SSD7348 - MOD10 RFI RESPONSE

We refer to Penrith Council's letter, dated 21 July 2022, providing comments on SSD7348 MOD10.

SSD7348 MOD10 – Penrith Council RFI Response, letter dated 13.04.22

Revised Precinct 5 layout

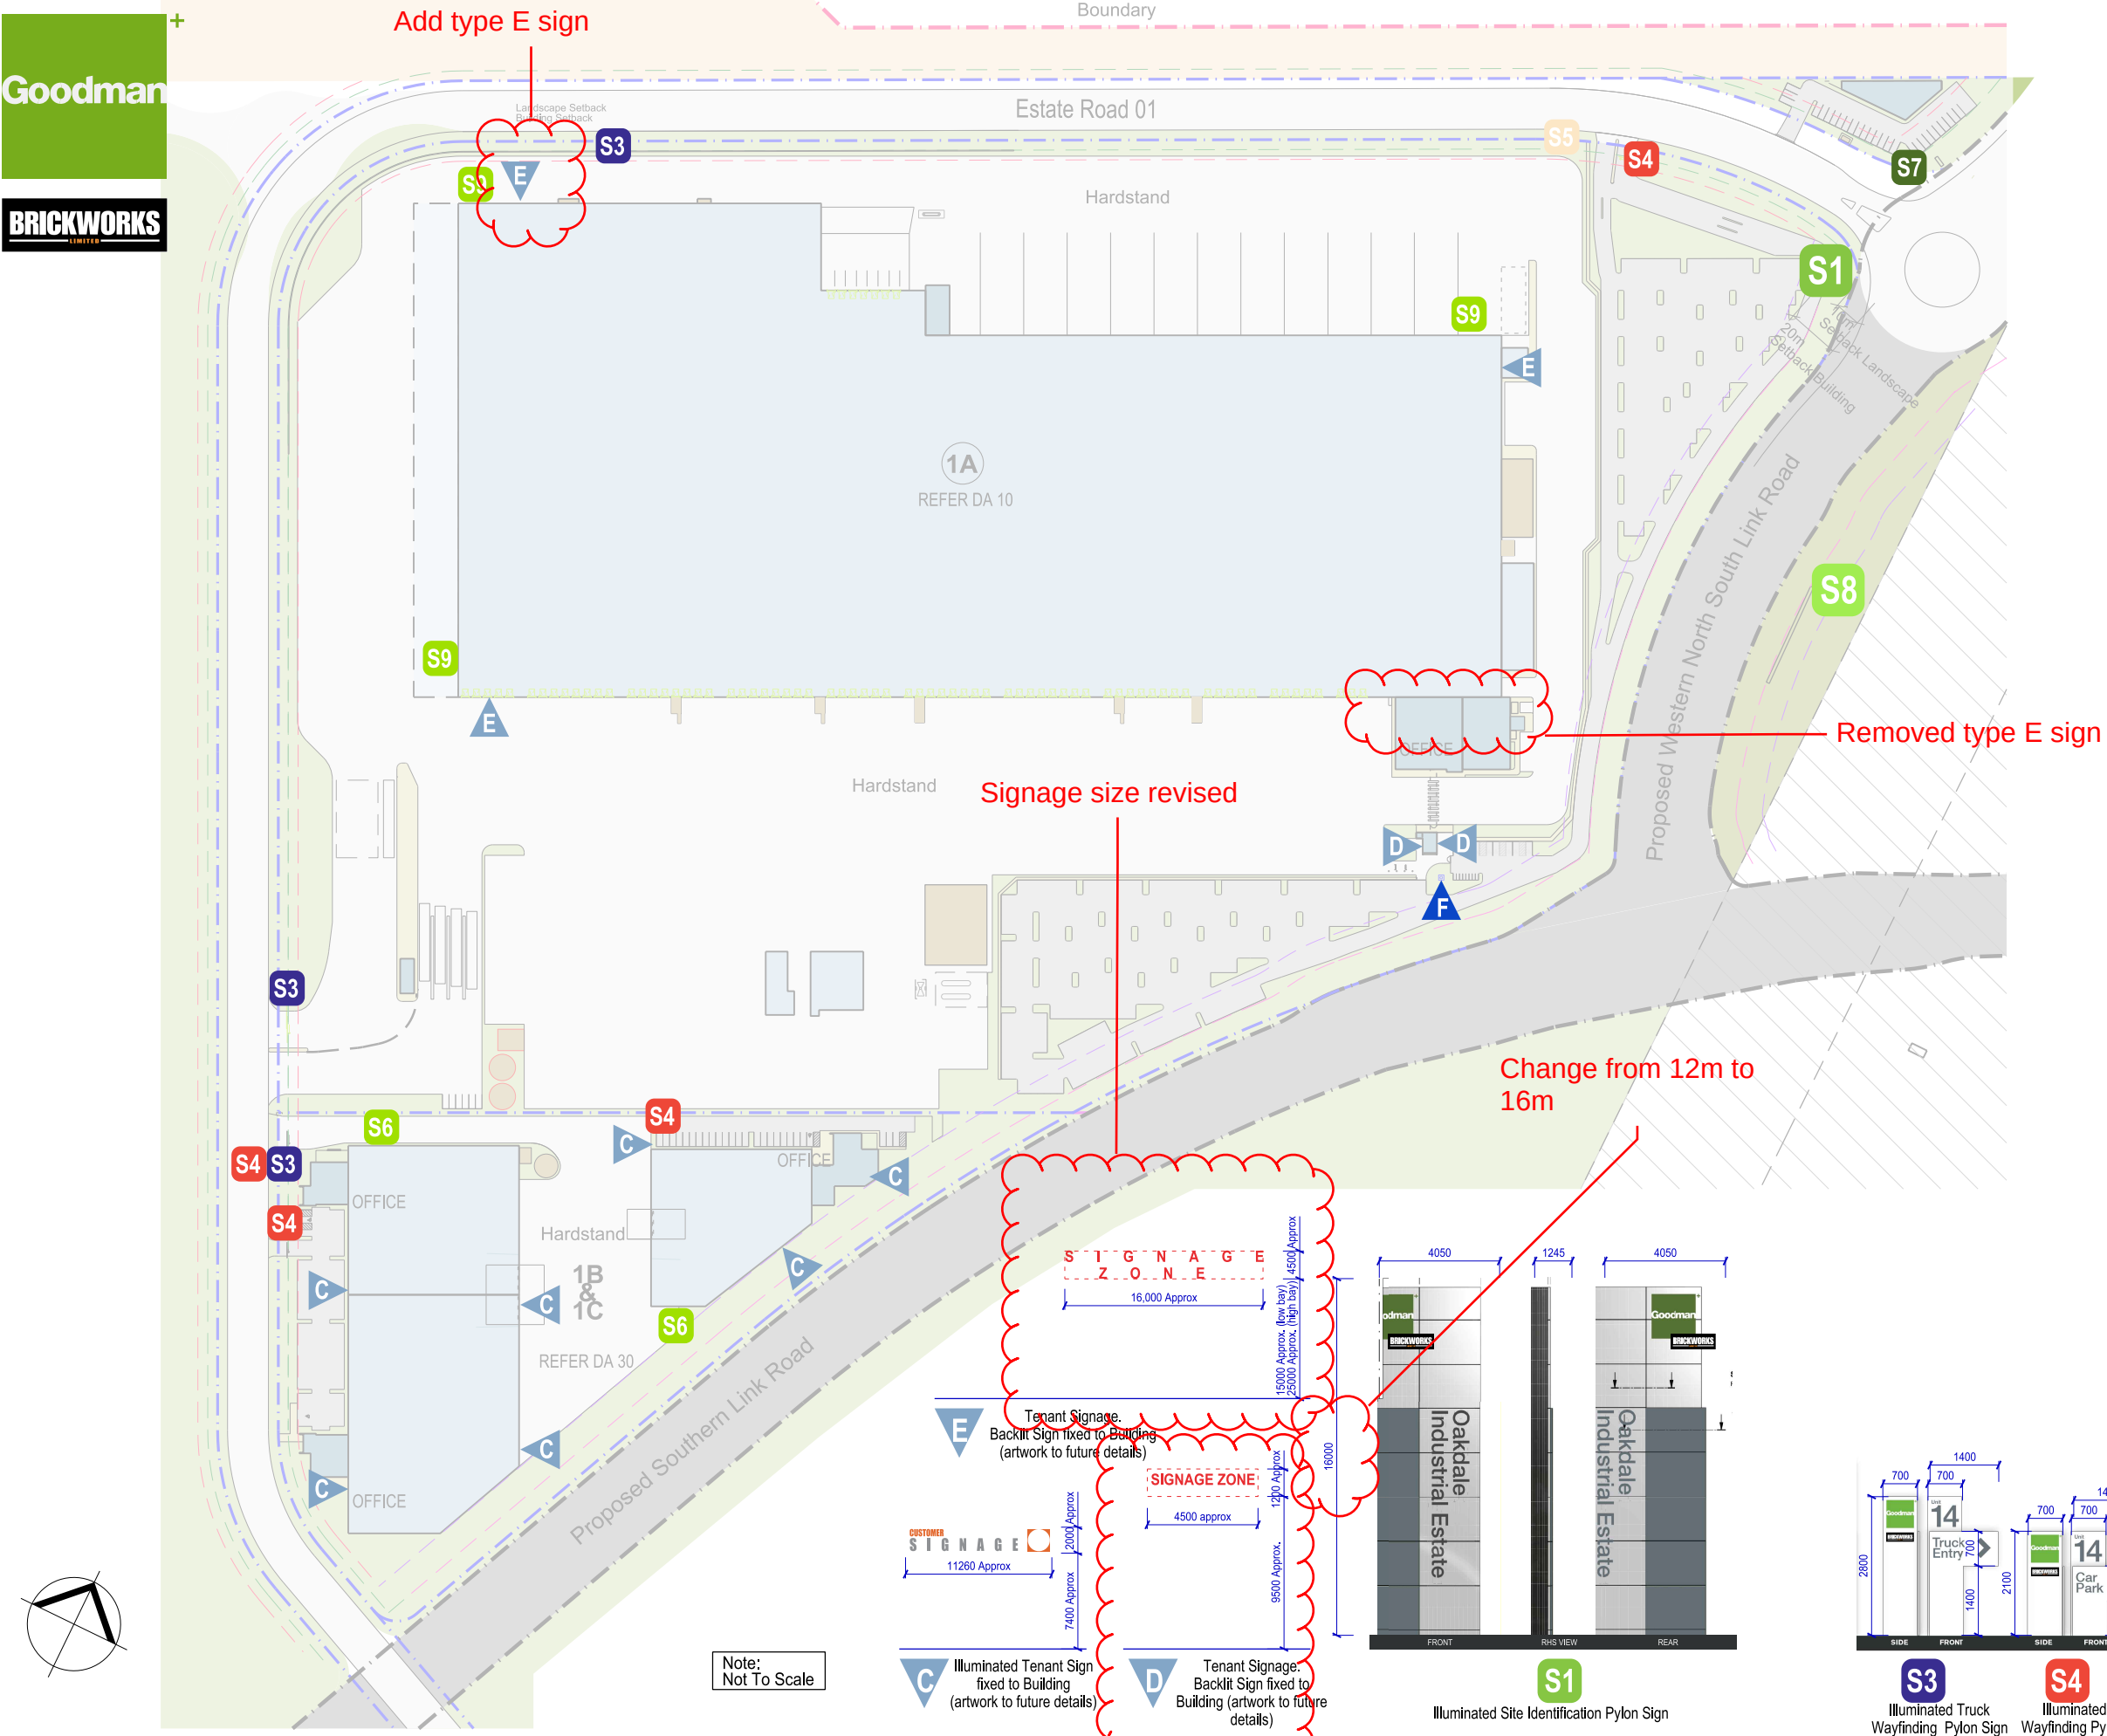
RFI		Response
1	Planning Considerations	
(d)	<p>Council objects to the site layout proposed for Warehouses 5A and 5B.</p> <p>Council strongly recommends that the Department request that the site layout be amended to provide safe and separated access from the staff and visitor parking to each office and warehouse. Future development applications for warehousing in this arrangement will not be supported by Council.</p> <p>Approval for the current layout will set an undesirable and unsafe precedence which has been avoided in the Precinct thus far.</p> <p>Staff and visitors must not be required to cross heavy vehicle driveways and manoeuvring areas. Secondary measures such as line-marking and boom gates should not be considered. Secondary measures are subject to user error and Council cannot manage compliance with consent conditions surrounding use and management of such systems.</p>	<ul style="list-style-type: none">As Masterplan update (Precinct 5) removed from MOD10 application – no longer relevant.

<p>The access driveways and crossovers within the cul-de-sac of Tundra Close are not perpendicular to the roadway (see access for warehouse 5A2) which should not be supported.</p>	<ul style="list-style-type: none"> ▪ N/A - Masterplan update removed.
<p>Due to the number of access points provided to each building from Tundra Close, competing, and unsupportable heavy and light vehicle manoeuvres will likely occur. Staff and visitor parking access is to be separated and located furthest from the heavy vehicle access/egress points.</p>	<ul style="list-style-type: none"> ▪ N/A - Masterplan update removed.
<p>Tundra Close could be extend toward east to provide sufficient and safe separated heavy vehicle access.</p>	<ul style="list-style-type: none"> ▪ N/A - Masterplan update removed.
<p>Strong consideration shall be given to requiring shared truck entry and exit point for the two warehouses. Warehouse 5A1 could also be rotated 90 degrees clockwise to separate access.</p>	<ul style="list-style-type: none"> ▪ N/A - Masterplan update removed.

<p>Warehouse 5A2 is not provided with separated entry and exit points for heavy vehicles. It has not been made clear from plans provided, that a conflict will not arise when entering and exiting heavy vehicles meet on this same driveway. Separate entry and access points for heavy vehicles are to be provided for 5A2.</p>	<ul style="list-style-type: none"> ▪ N/A - Masterplan update removed.
<p>The current arrangement of entry and exit points in the cul-de-sac and location and design of truck manoeuvring/driveways and staff parking and access points should not be supported and must be re-designed.</p>	<ul style="list-style-type: none"> ▪ N/A - Masterplan update removed.
<p>Should this warehouse be split into two and operated by separate tenants, the rear (northern) portion of the warehouse will need to be provided with staff and visitor parking which does not require pedestrians to traverse areas of hardstand which are utilised by</p>	<ul style="list-style-type: none"> ▪ N/A - Masterplan update removed.

heavy vehicles and which does not require excessively long paths of travel.	
The layout would need to be amended to provide separated heavy vehicle, and staff and visitor access points.	<ul style="list-style-type: none"> ▪ N/A - Masterplan update removed.
Warehouse buildings including gatehouse structures are to be provided with easily accessible and convenient amenities and staff areas. It is noted that the second gatehouse and dock office (north elevation of Warehouse 5A) is relatively isolated from the office amenities and that any additional warehouse amenities are not indicated.	<ul style="list-style-type: none"> ▪ N/A - Masterplan update removed.

(g)	The proposed modification seeks a total of five (5) driveways accessing the site from the cul-de-sac. Heavy vehicle movements will conflict with staff and visitor car parking movements within the cul-de-sac, which is not supported.	<ul style="list-style-type: none"> ▪ N/A - Masterplan update removed.
	Safety concerns are raised for the location of the staff car park for Warehouse 5A1 as pedestrians will be required to cross the heavy vehicle driveway to access the building which is not supported. The previously approved Masterplan for Precinct 5 had separated the heavy vehicle areas from the staff car parking areas. The use of a boom gate and traffic signal system is not supported.	<ul style="list-style-type: none"> ▪ N/A - Masterplan update removed.

Figure 1 - Sign 1- approved

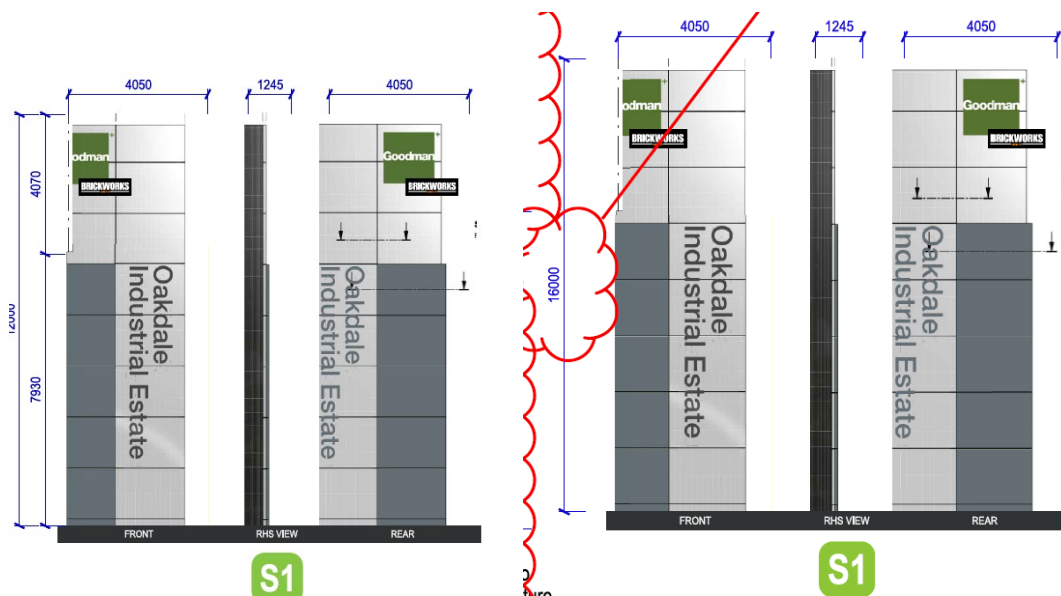
(e) Signage	
No objections are raised to the reduction in scale of building identification signs “D” and “E” or to the requisite signage zones.	<ul style="list-style-type: none"> ▪ Noted.
<p>Section 2.1.3 and Section 3.2 of the applicant’s statement do not clarify the proposed final height of the approved pole sign and it is assumed that the proposal is to increase the height of the pole sign by 4m.</p> <p>Pole signage shall not be raised in height. The additional height is not required to assist in brand advertising or wayfinding. An increase in height to match the bulk or scale of the building is not adequate justification and will set an undesirable precedence.</p>	<ul style="list-style-type: none"> ▪ The proposed 16m high pylon sign is considered appropriately scaled when considering contextually against the adjacent 36m high host building; ▪ The signage is not used for advertising, but rather important ‘building’ and ‘business’ identification. ▪ The proposal will not set an undesirable precedent as more recessively sized entry signage would be appropriate in alternative precincts where standard warehouses (13.7m ridge height) are proposed. ▪ The proposed pylon sign is located away from any sensitive receivers.

<p>The proposal to increase signage height does not comply with the DCP requirements for signs in the Estate (Section C9 and E6 of the Penrith DCP) which require the height of pole signs to be no greater than 7m.</p>	<ul style="list-style-type: none"> ▪ As SSD7348 is State Significant Development, the Penrith DCP's 7m signage height control does not apply to the proposal and not therefore relevant to the assessment.
<p>The proposal to raise the height of the pole sign is contrary to the objectives and matters for consideration under SEPP (Industry and Employment) 2021 – Chapter 3, Schedule 5 as the signage is:</p> <ul style="list-style-type: none"> - not compatible with the desired future character of the area (as is set by the limiting of pole signs to 7m under the DCP) and, - will detract from the amenity and visual quality of the area, will have a dominating effect, and - the scale is not appropriate for the streetscape, setting and landscape, and - will not contribute positively to the streetscape, - does not reduce clutter, screen unsightliness, or provide visual interest, and - will protrude above nearby canopy. 	<ul style="list-style-type: none"> ▪ Goodman disagrees that the proposal is not compatible with Schedule 5 of SEPP (Industry and Employment) 2021 - refer to assessment of the proposal against Schedule 5, included in SEE. In particular: <ul style="list-style-type: none"> – The signage is appropriately scaled to respond to the significant scale of adjacent industrial built form, which characterises the area. – It is not agreed that the signage will detract from the visual quality of the area and not contribute positively to the streetscape. It will provide an appropriately scaled entry sign to match that of the Oakdale West Estate precinct. – The proposed pylon entry sign will not have a 'dominating effect' when viewed contextually against the significant adjacent warehouses. – The proposed S1 sign is the only one of its kind proposed for the entire Oakdale West Estate precinct. As the S1 sign has already been approved for this location and with the same width, it is not agreed that the additional 4m of height will result in additional or unacceptable visual clutter. – It is argued that the scale of the sign will provide visual interest, providing suitable announcement of Oakdale West Estate at this key gateway location on entering the precinct. – Given that the purpose of the signage is to identify the Oakdale West precinct, it is considered necessary to be of a

scale to necessarily protrude above the nearby canopy, and not be obscured by it.
(f)	Gross floor area (GFA)	
	No objection is raised in relation to Precinct gross floor area increase, noting that the overall OWE GFA remains as approved.	<ul style="list-style-type: none"> ▪ Noted.
2	Development Engineering Considerations
